# Heritage Impact Assessment

Flat 3, 40 Montagu  
Square, London

March 2021 | Project Ref 6604

1 Roof Lantern - South Elevation Detail

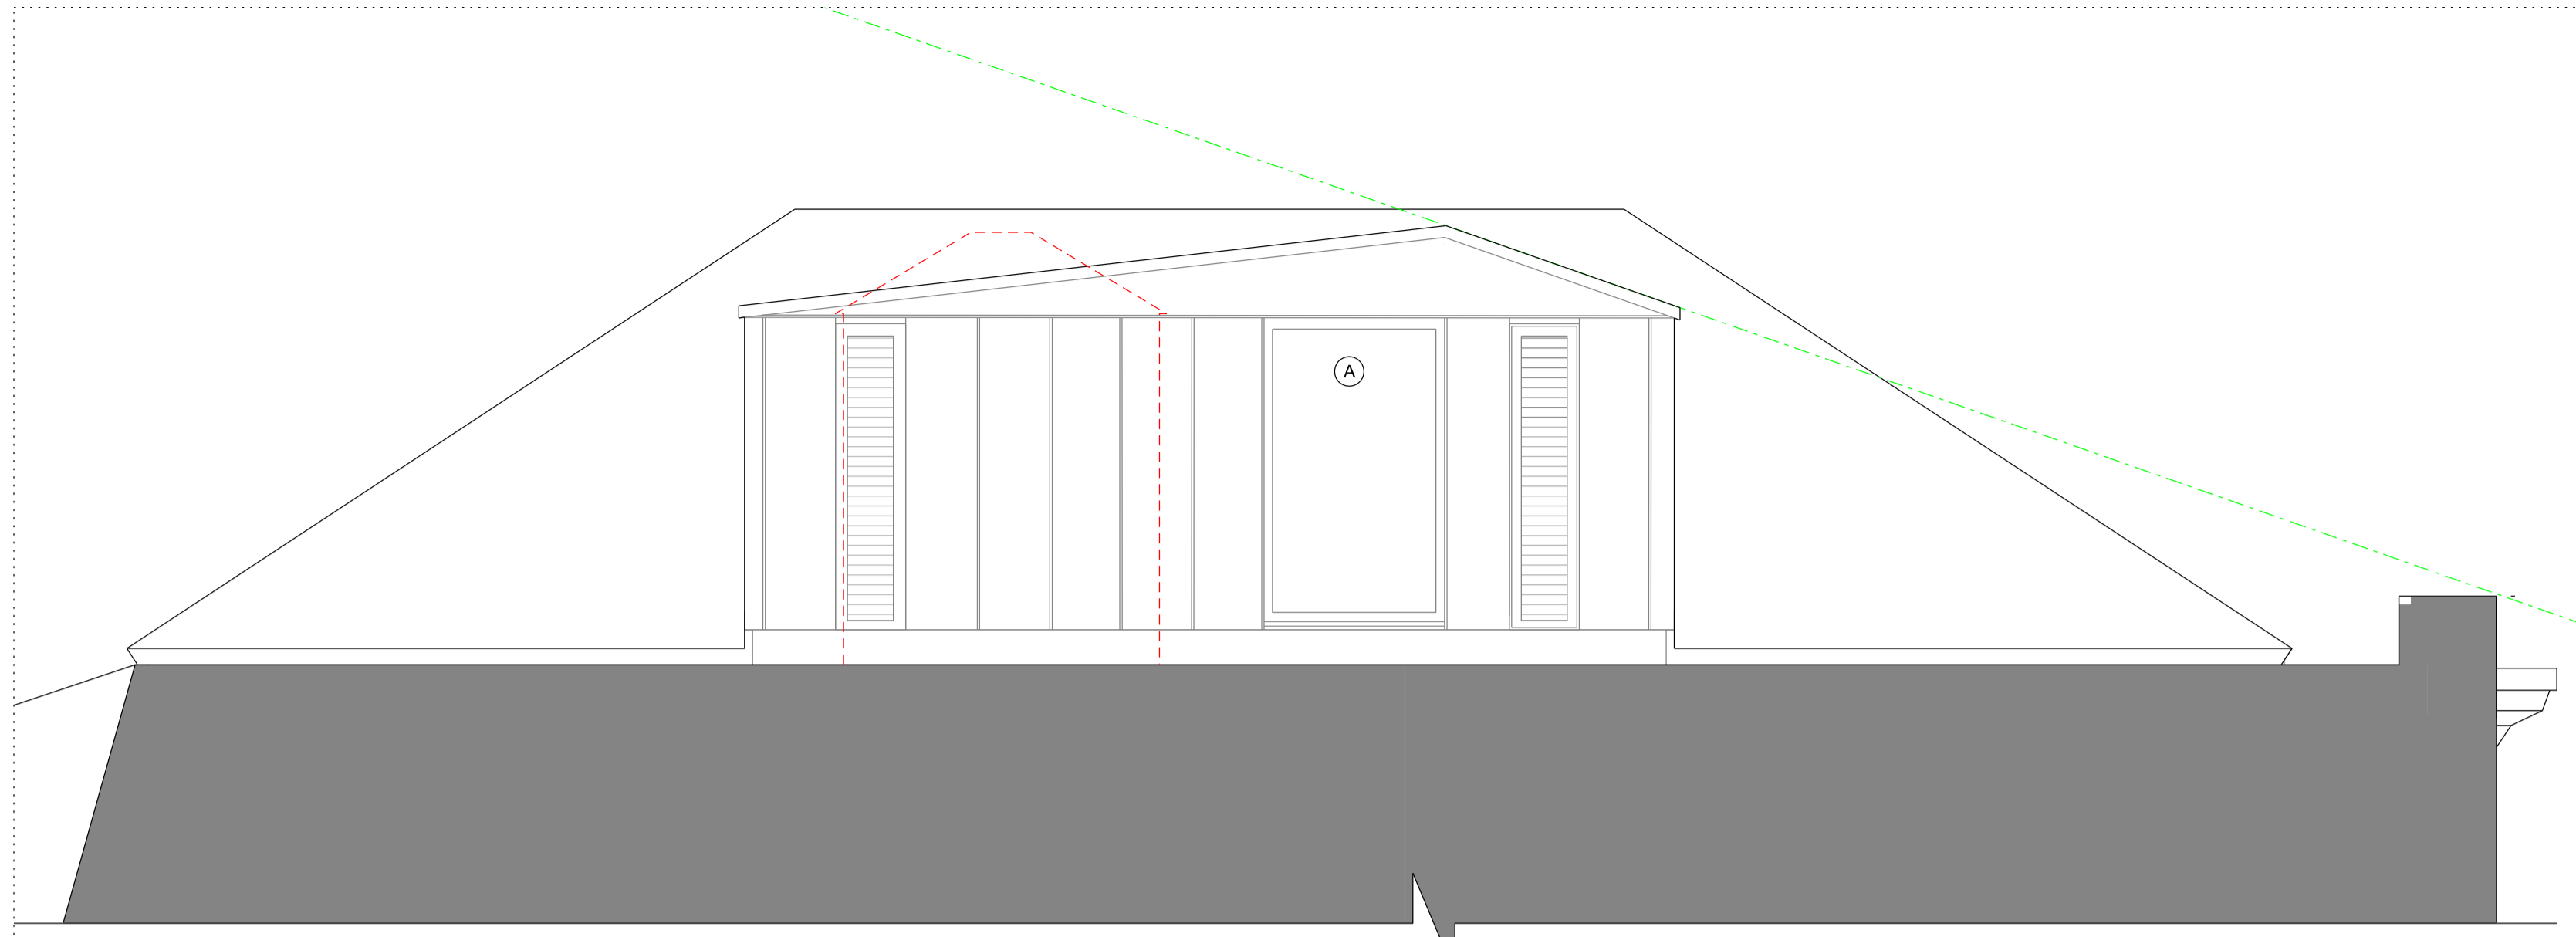
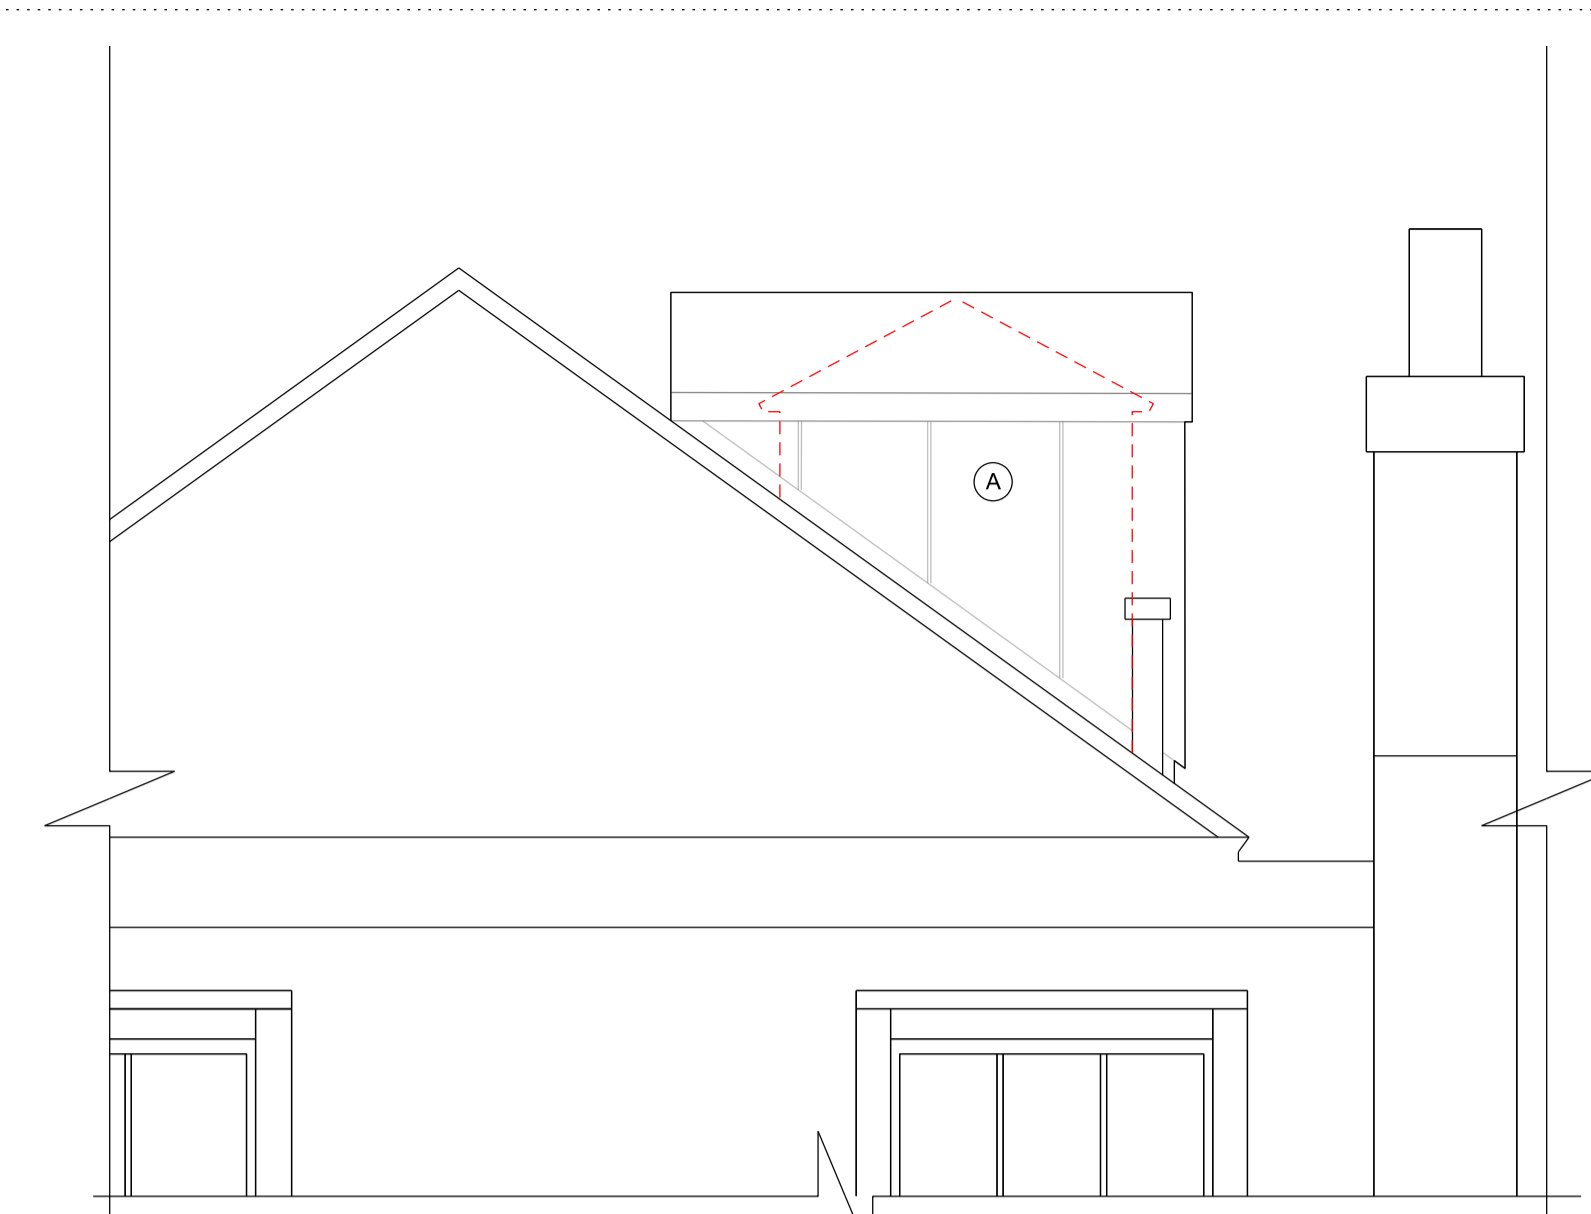
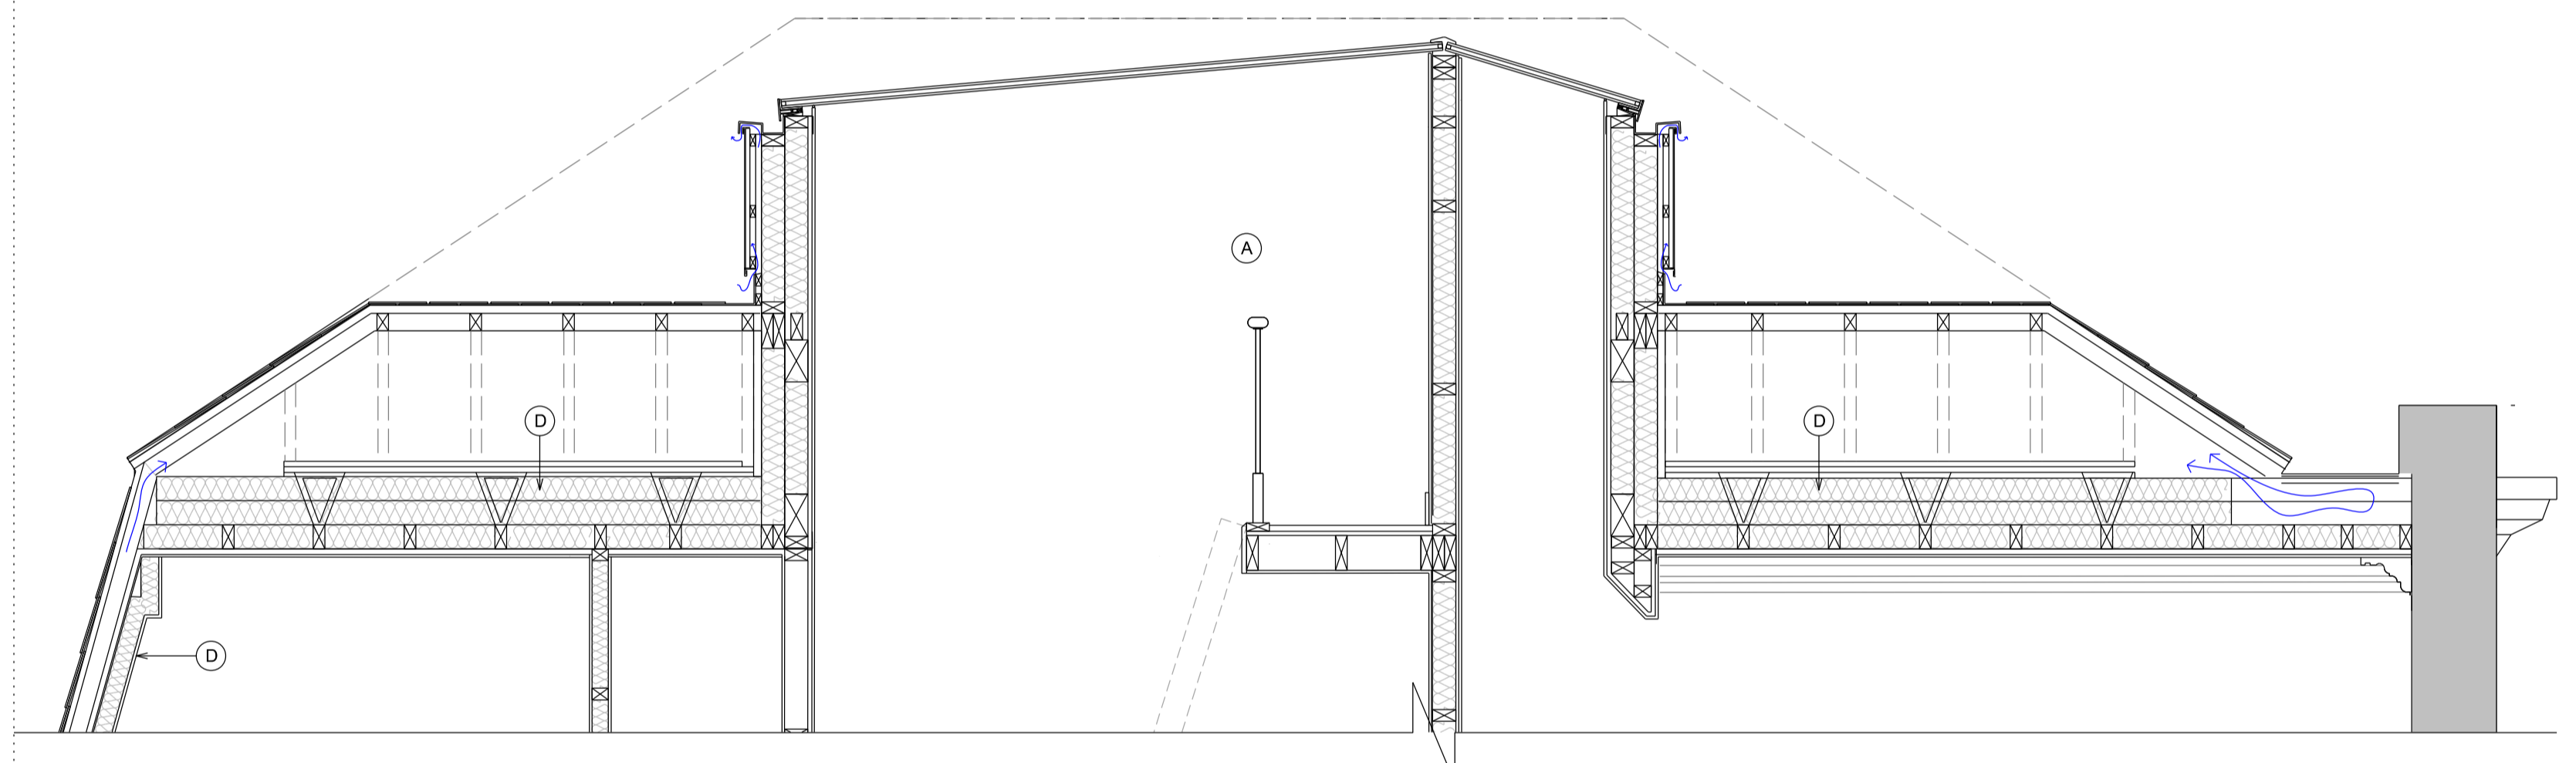
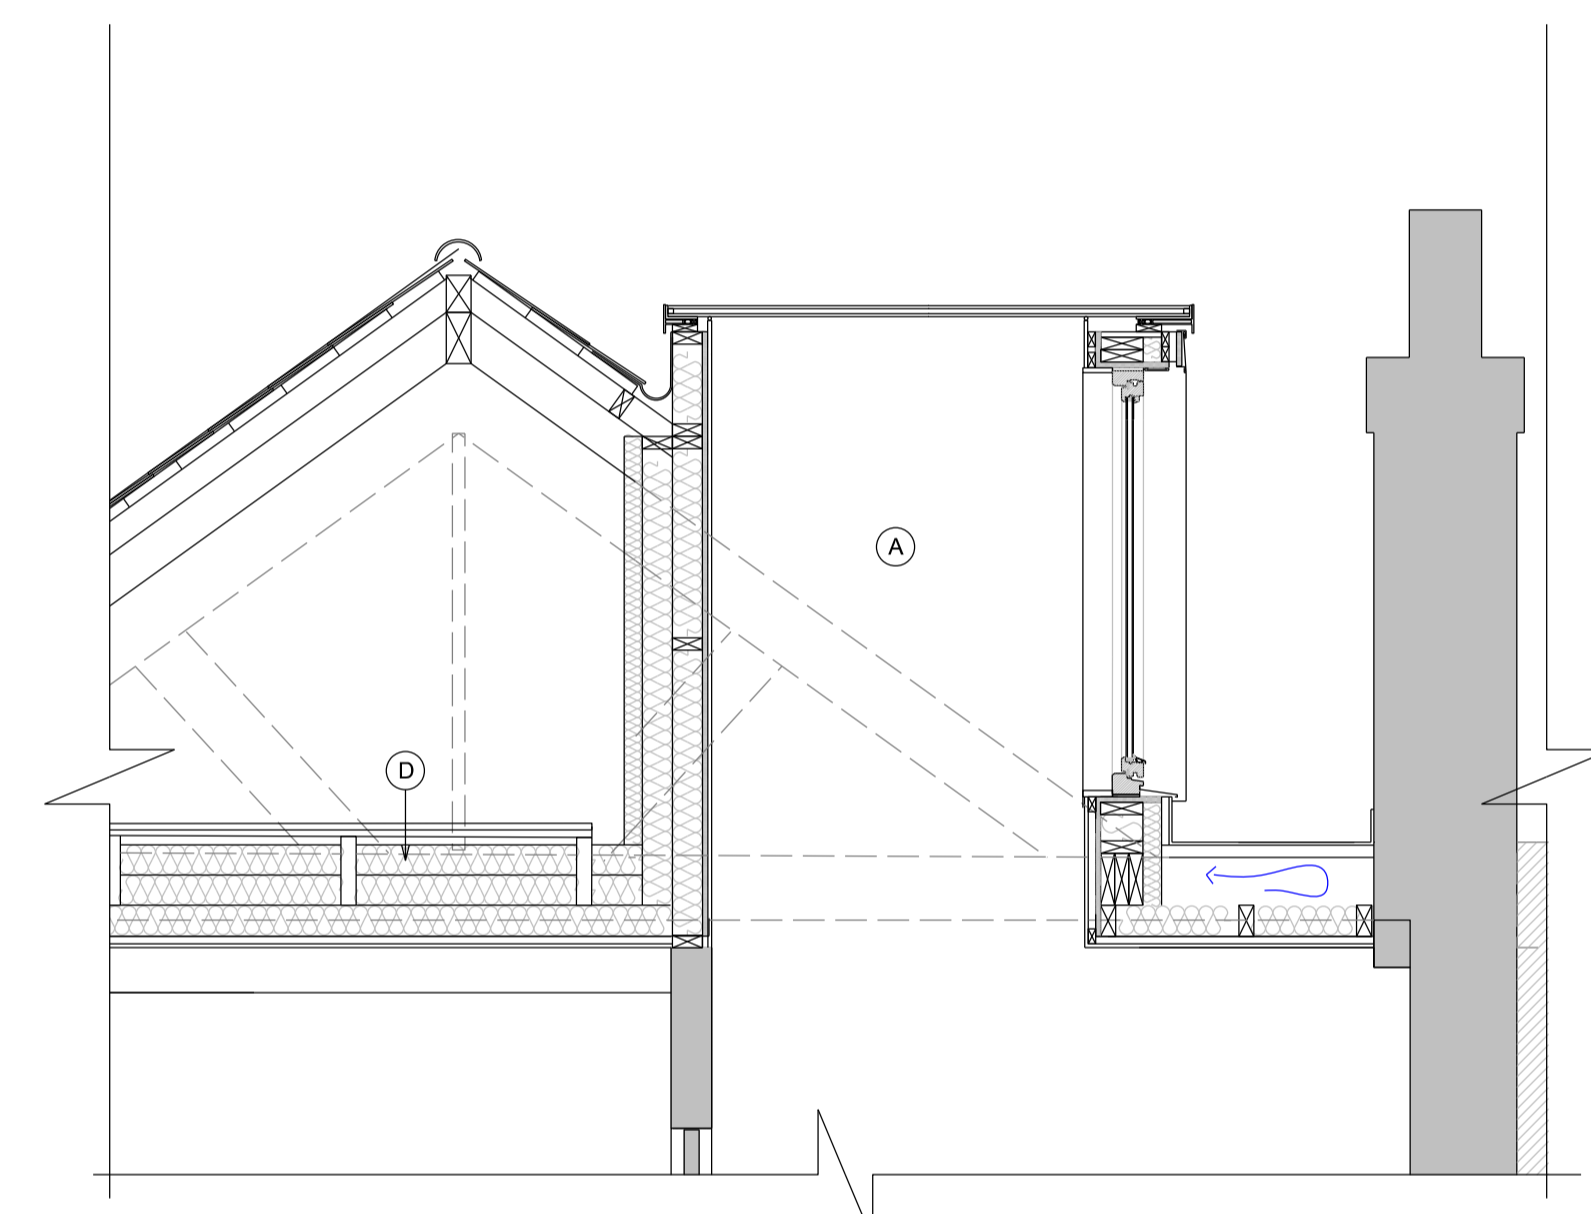
*In terms of the proposed works to the roof lantern, the date of the roof should be established before we can consent to the loss of fabric, including roof timbers. The hipped roof appears to be historic – the same roof form is repeated on almost all of the Montagu Square buildings which have the same two-storey bay as no. 40. If the roof is indeed original then the loss of roof*

*timbers to allow for an enlarged roof lantern would not be acceptable. The fabric of the lanterns itself does not appear to be of special interest - there would be no objection to the replacement of the existing lantern with one of the same volume.*

- 4.6** A new and enlarged rooflight is proposed. This will cut out more of the hipped roof, but the fabric of that structure is very unlikely to be original. The new rooflight will not be visible from ground level. In design terms it should be compared favourably with the lantern at 39 Montagu Square that was approved in 2008 (08/07584/LBC) (Figure 8). Other broadly similar lanterns have been approved, including 2 Montagu Square (14/0557 and 16/03489). When observed from roof level, the whole area abounds with incremental alterations and changes, most of which are hidden from public view and have no effect on the special interest of the townscape – including the structure on the roof of the neighbouring listed building, 41 Montagu Square (Figure 7).
